DRB Application No.: **05DRB-01286 (P&F)**
Project Name: **NO ALBUQ. ACRES, UNIT B**
Agent: **Wayjohn Surveying**

DRB Comments

**RE: Lots 31 -32, Block 9, Tract A, Unit B, North Albuquerque
Acres**

BLOCK 9, TRACT A, UNIT B,
NORTH ALBUQUERQUE ACRES

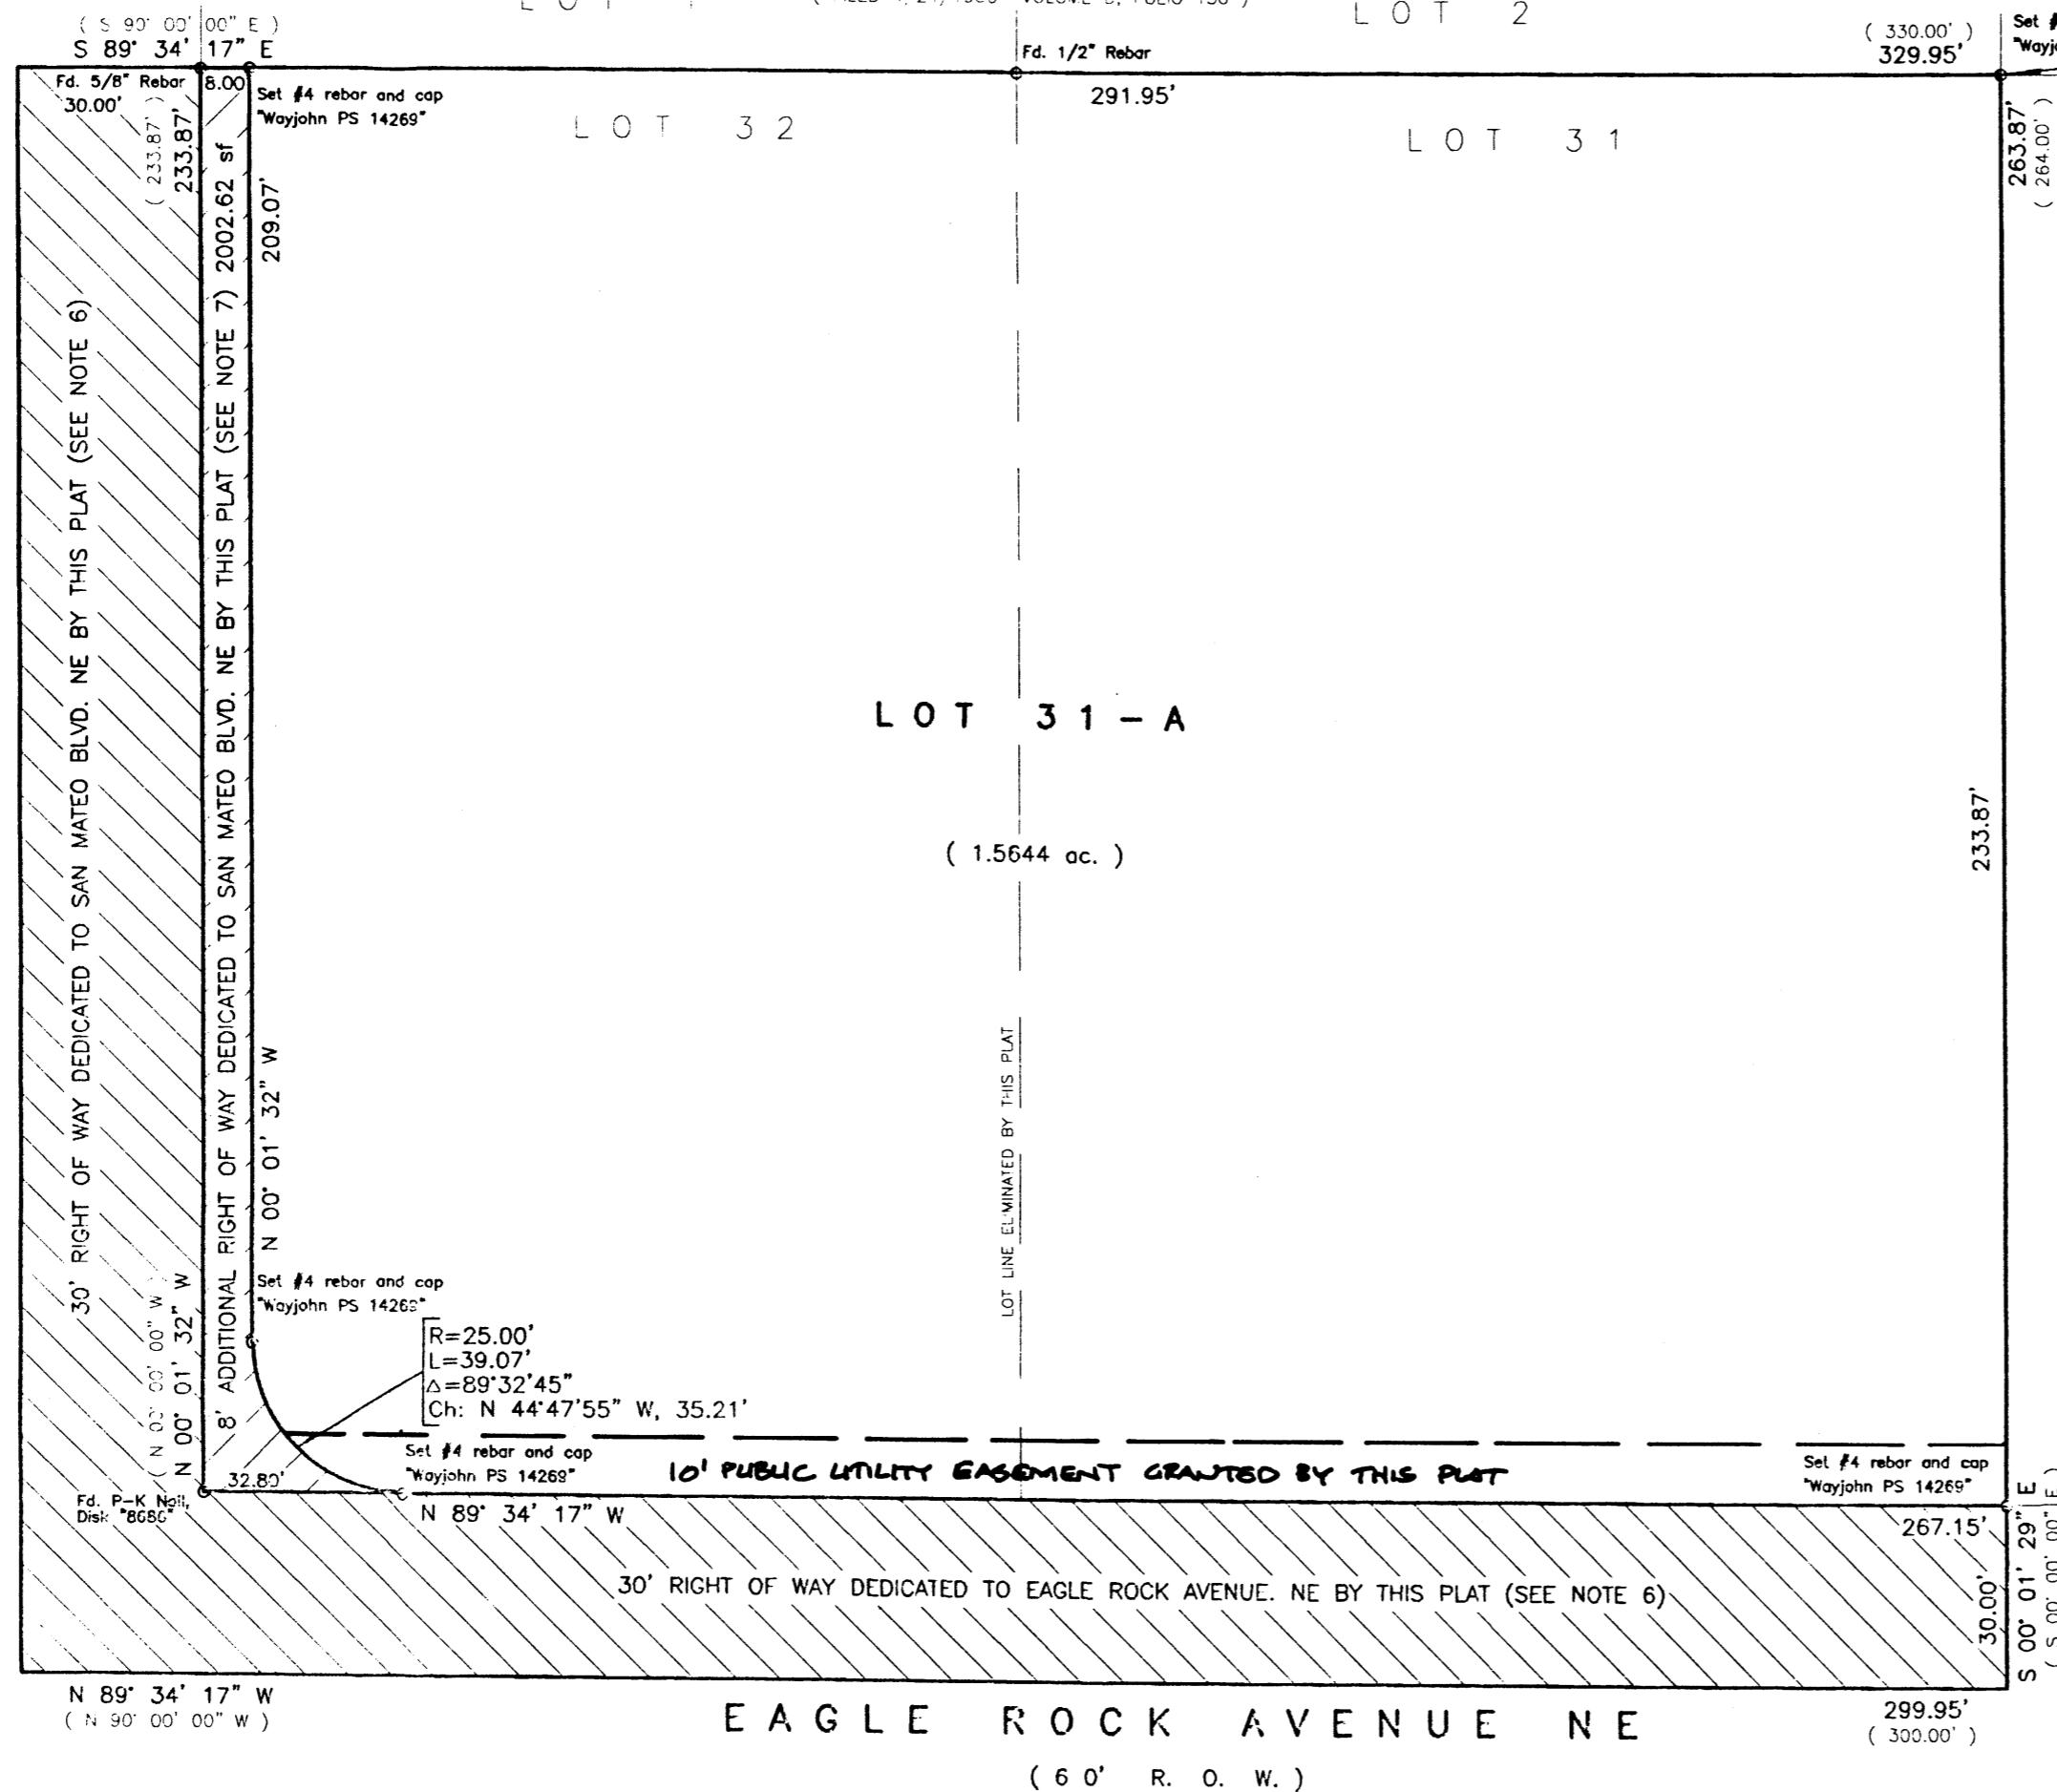
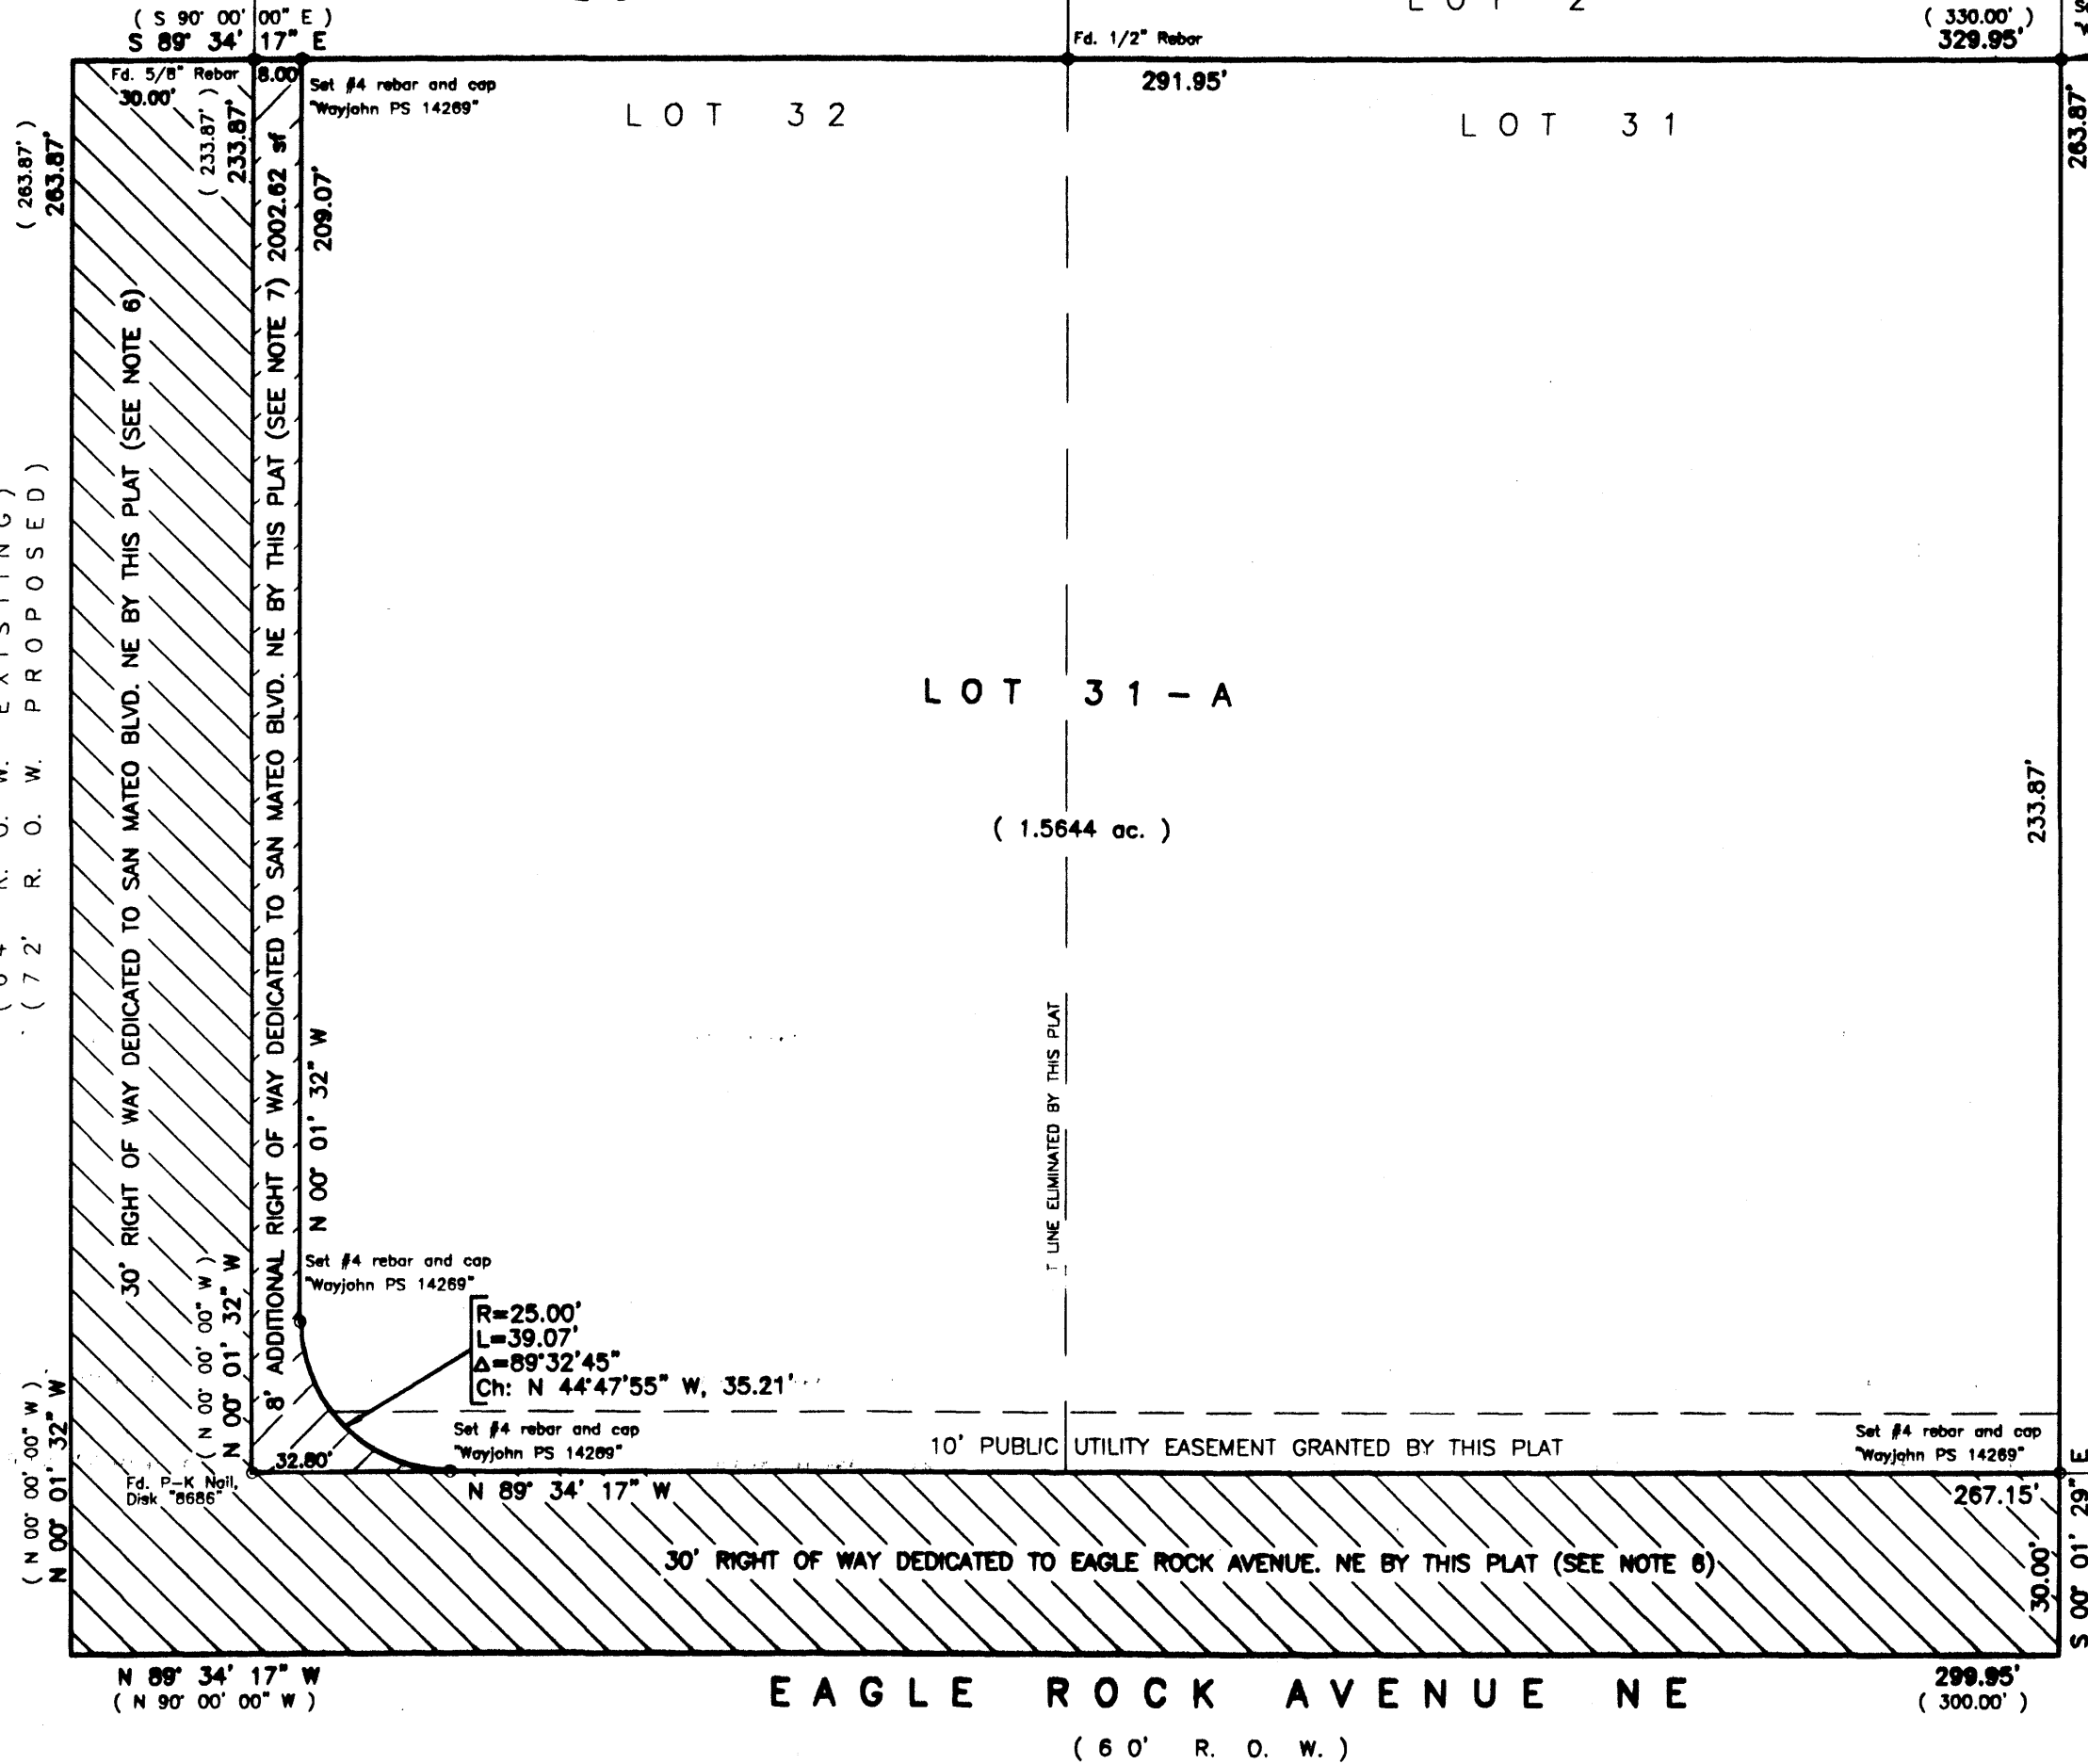
Updated signatures are needed for the Final Plat, to include Environmental Health Department. It appears the Heading: Owner is needed for the Free Consent statement.

Please remove zoning note (3.) from Final Plat. A Solar Note consistent with § 14-14-4-7 is required, specific to this type of request, i.e. use the words "THIS PLAT" (rather than the words "REQUESTED FINAL ACTION") at the beginning of the note, and do not use the words "OR SITE DEVELOPMENT PLAN FOR SUBDIVISION" at the end of the note.
